BILLINGTON AND LANGHO PARISH COUNCIL
25, Washbrook Close, Barrow, Clitheroe, BB7 9BP
Tel: - 01254 824782
Email: - tracey@mccarney407.orangehome.co.uk

21st December 2011

3/2011/0959- Application for outline planning permission for the demolition of an existing garage and the erection of two detached dwellings including details of layout and access with all other matters reserved, at land adjacent to 65 Whalley Road, Langho.

Illustrative Elevation to Whalley Road

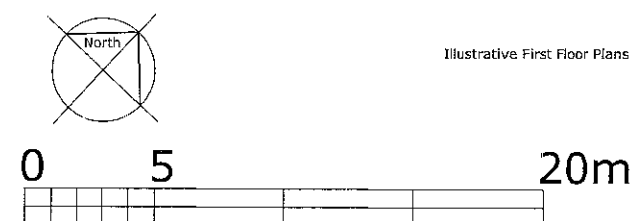
Parish Council object to this application as we have concerns about the height of the new development in terms of the existing street scene
